re: Response to Engineering Comments
Proposed Residential Development
2710 Draper Avenue - Ottawa

date: March 21, 2019

file: PG1630-MEMO.17

Further to your request and authorization, Paterson Group (Paterson) prepared the following memorandum to respond to the current City of Ottawa engineering review comments for the aforementioned site. This memorandum should be read in conjunction with our geotechnical Report PG1630-4 Revision 1 dated February 21, 2019.

Figure 3 - Section B - Static Loading (Proposed Conditions)

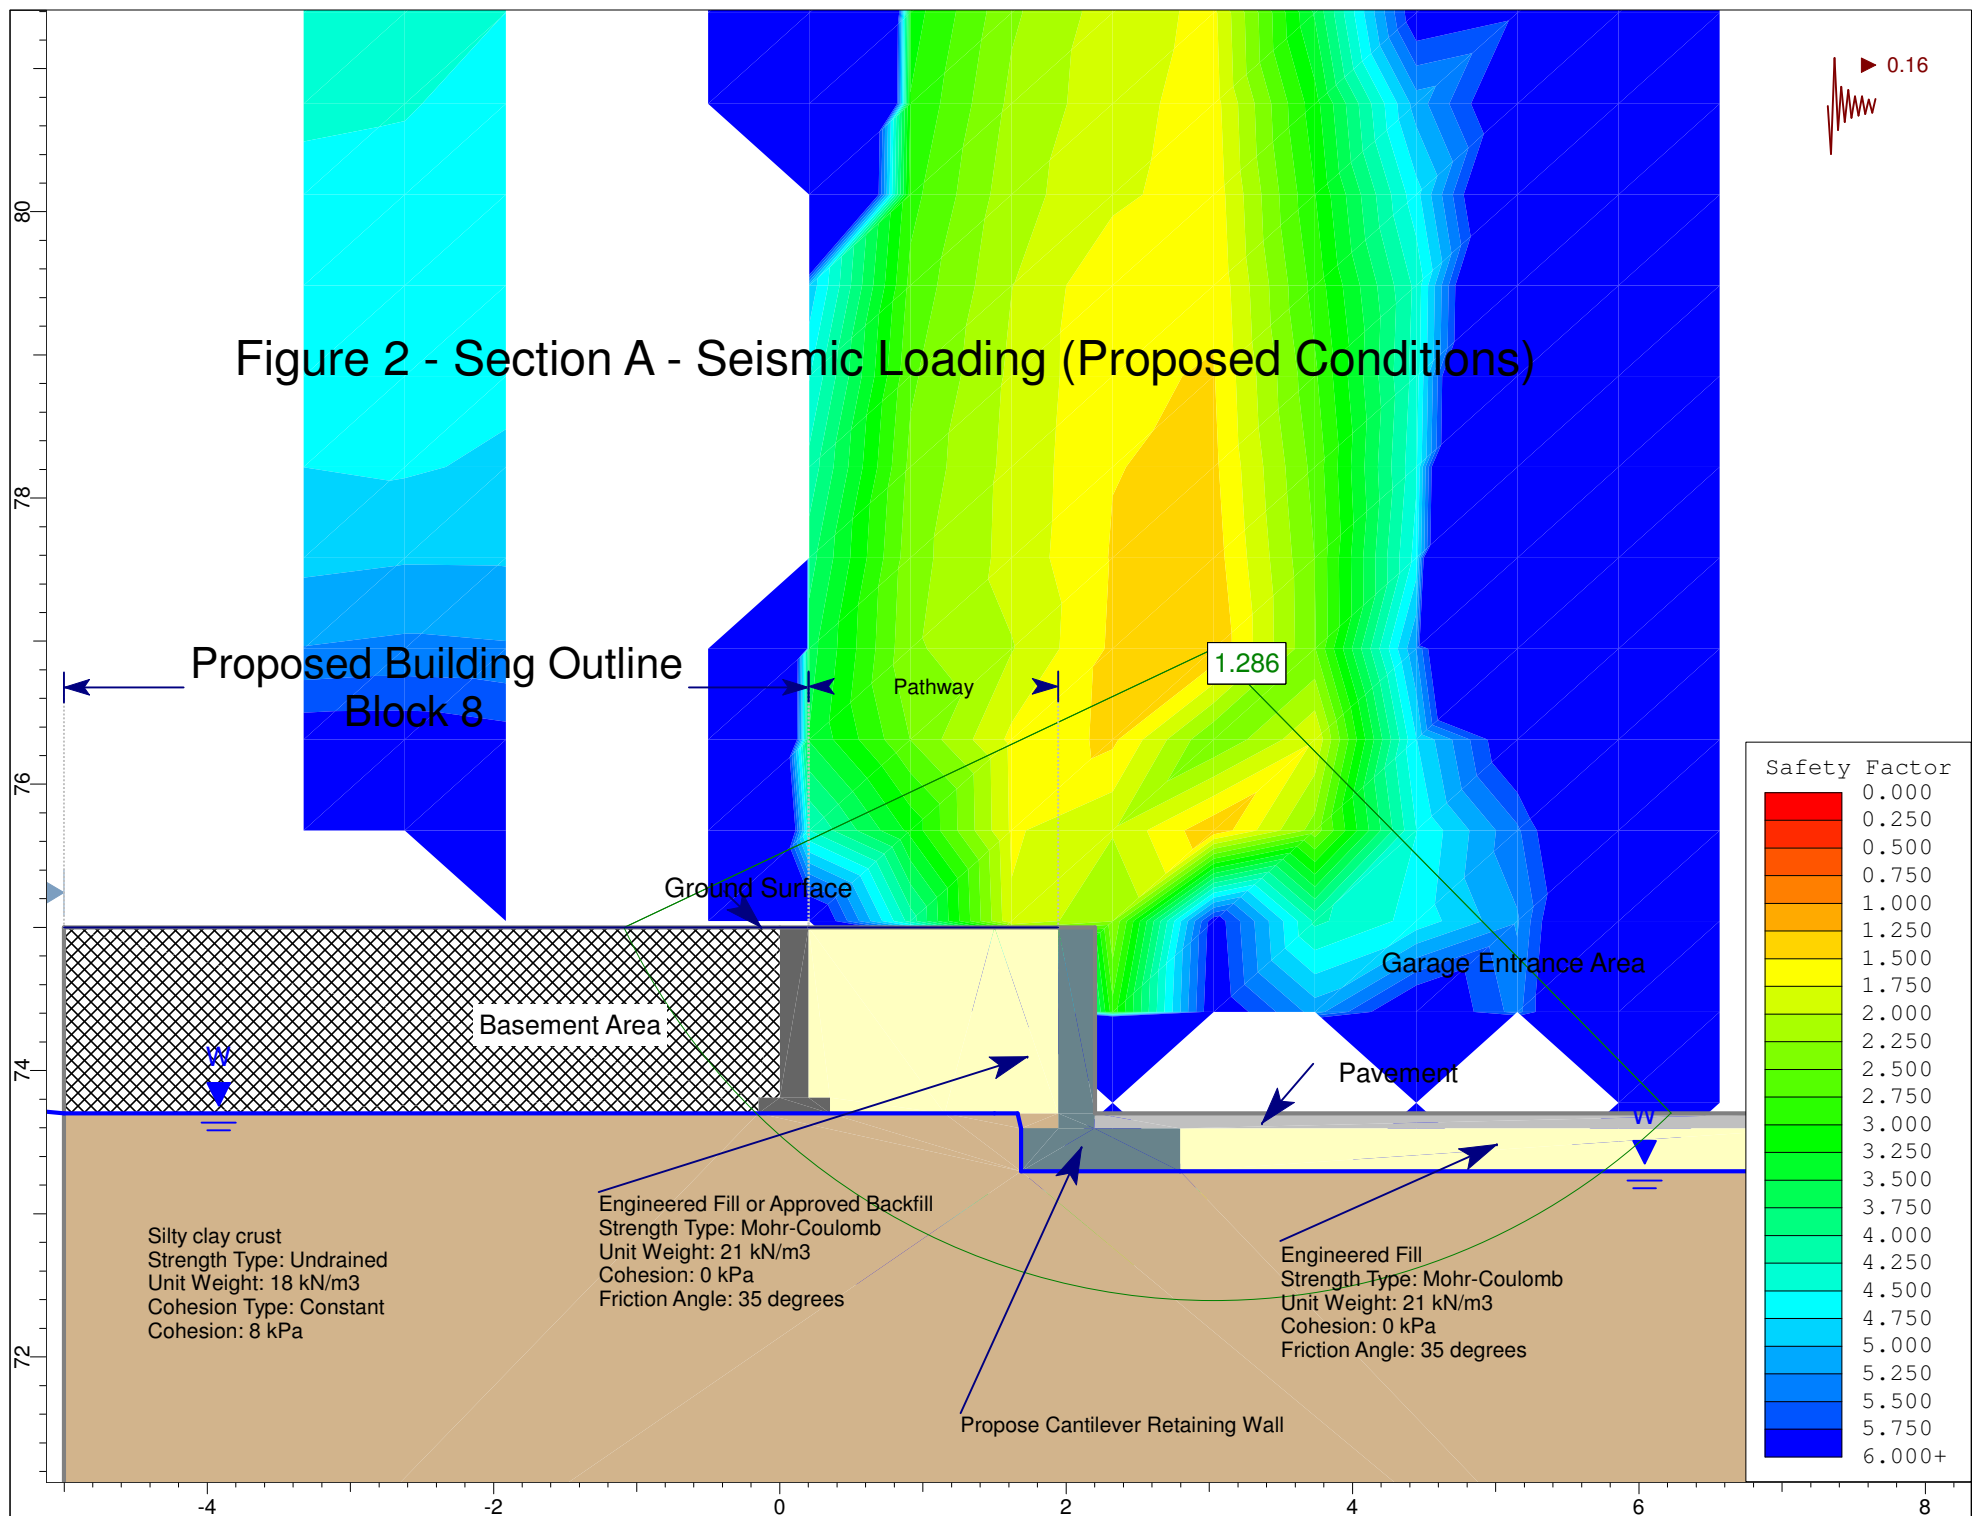
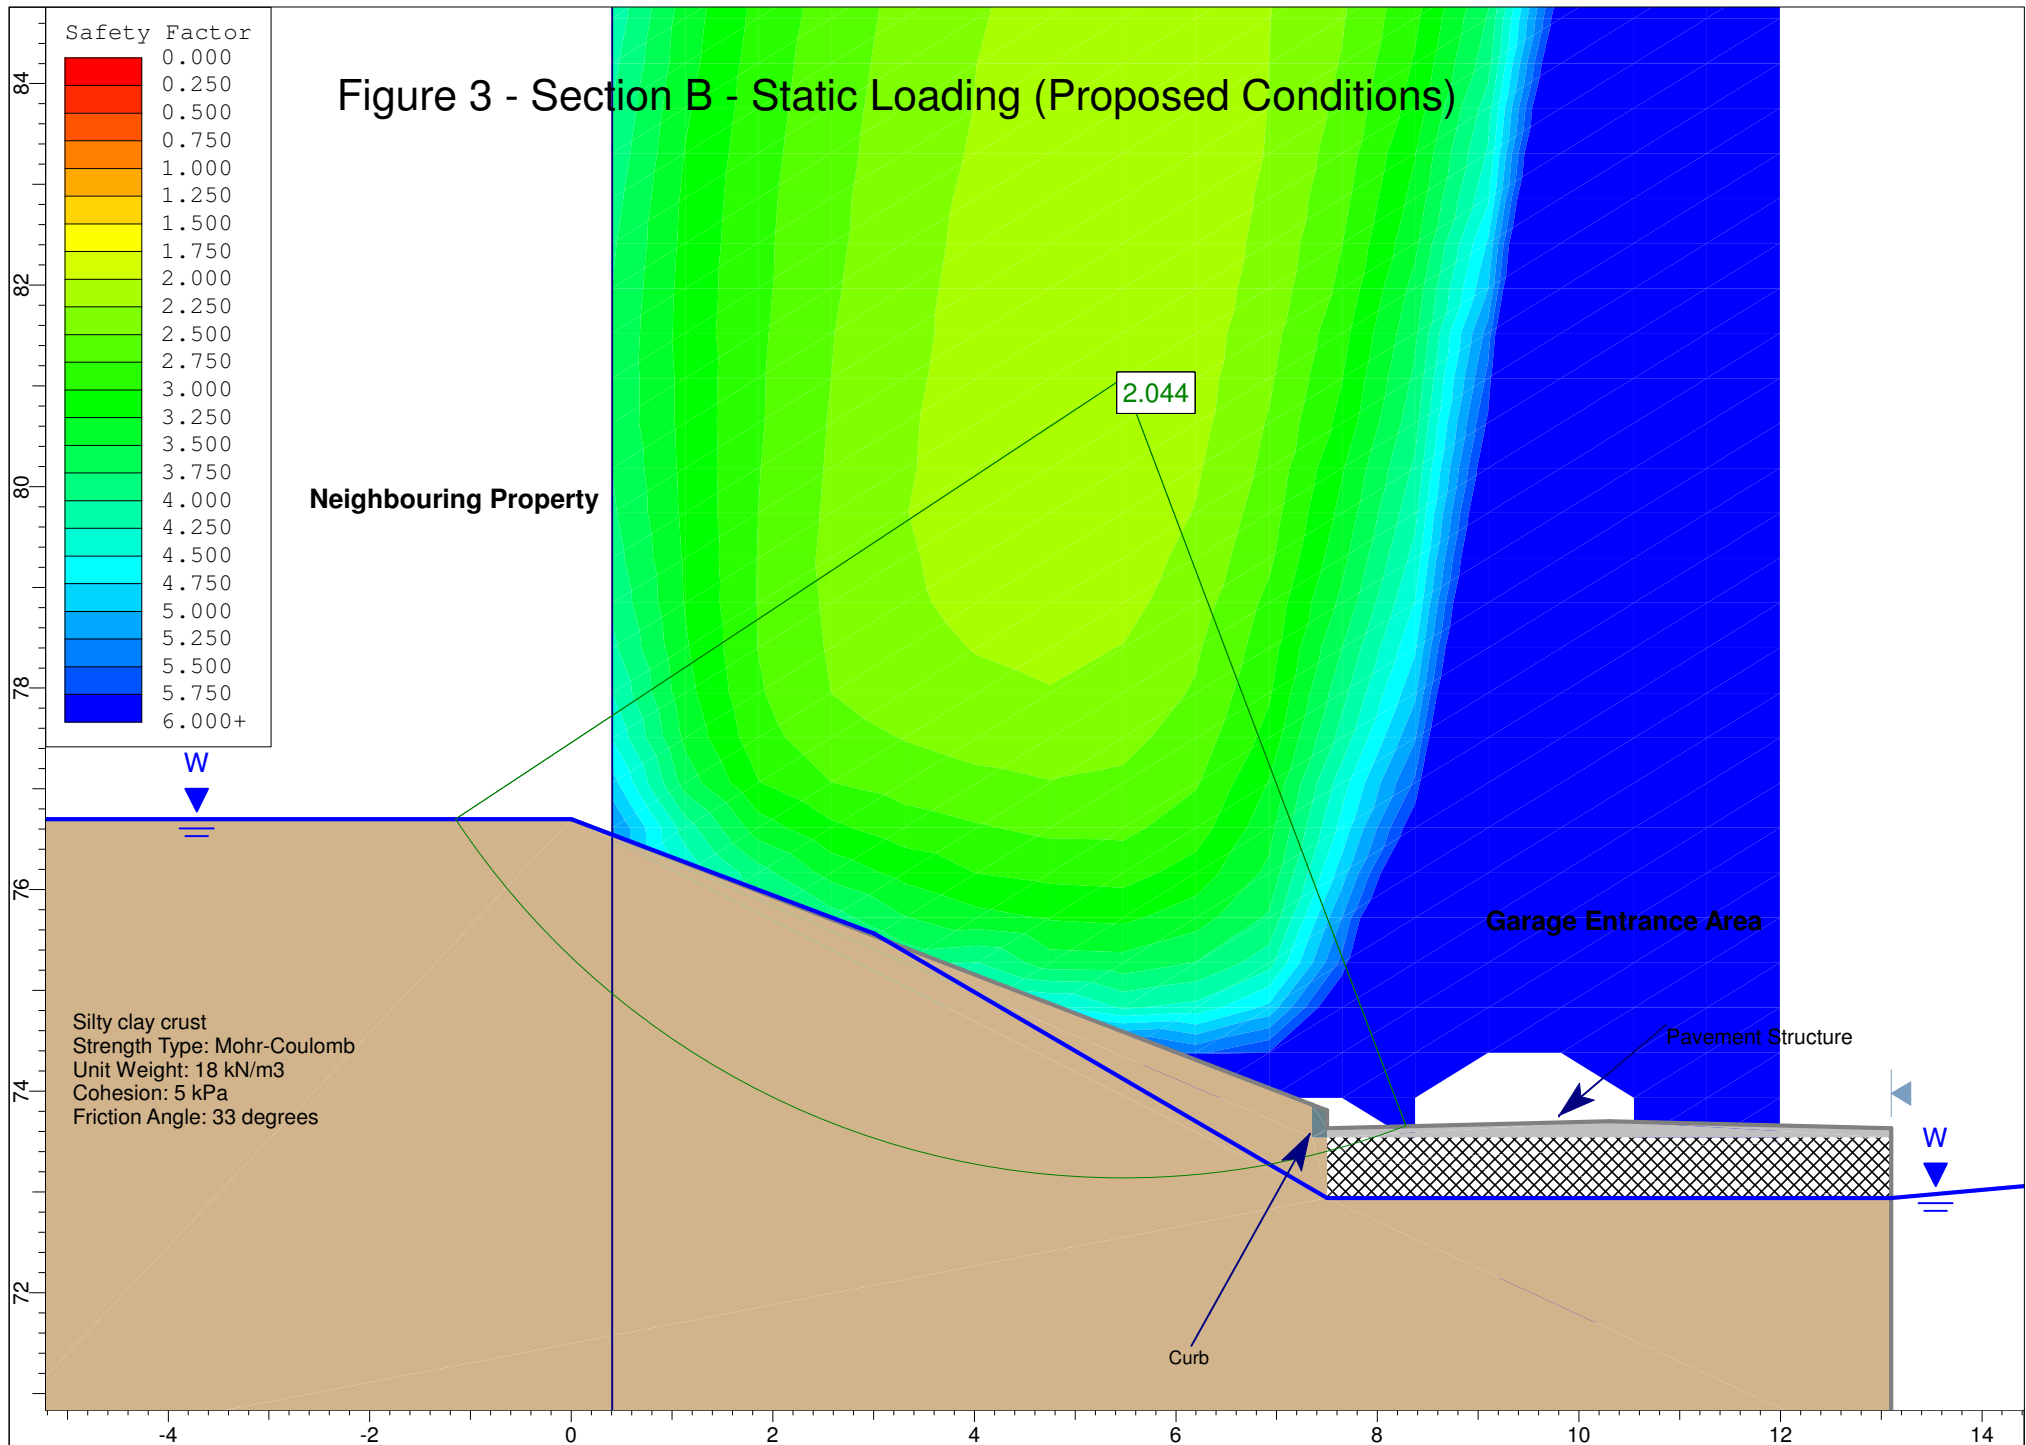
Comment: *A slope stability assessment memorandum is required to be provided from the Geotechnical Engineer of record assessing the slopes adjacent to the underground parking garage. This report shall address the stability of the slope as the overall height of the slope exceeds 2m.*

Response: Please refer to Subsection 6.9 in our revised Report PG1630-4 Revision 1 dated February 21, 2019. Paterson reviewed the following drawing prepared by DSEL:

It should be noted that this area was previously analyzed for slope stability; the current analysis supersedes previous slope stability analyses. Discussion regarding the proposed slope, as shown on the aforementioned grading plan has been included in Subsection 6.9 of Report PG1630-4 Revision 1 dated February 21, 2019. The proposed slope is considered stable from a geotechnical perspective.
